From: Nick Stevens [REDACTED]
Sent: 09 November 2017 07:30
To: Planning.Responses
Subject: Re: Planning Compliance Case ENF/401/17

Planning application FG/172/17/HH

PROPOSED ELEVATIONS 1:100@A3

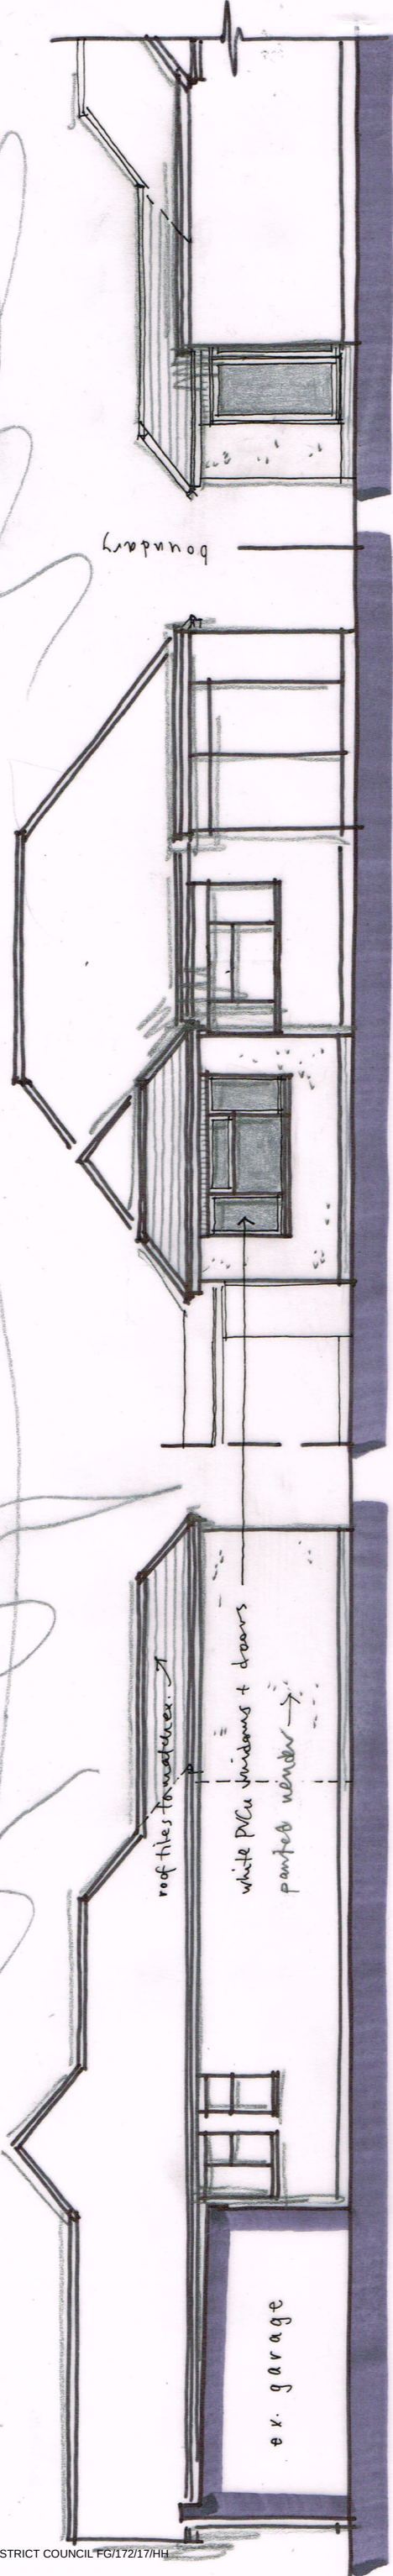
1. There are no bedrooms on the plans
I am led to believe there are to be four.
2. The plans seem to indicate that the drains are to be covered and not moved.
3. The rendering has already been actioned and is not in keeping with the adjacent properties.
- 4 To date there is no yellow application
notice on view.
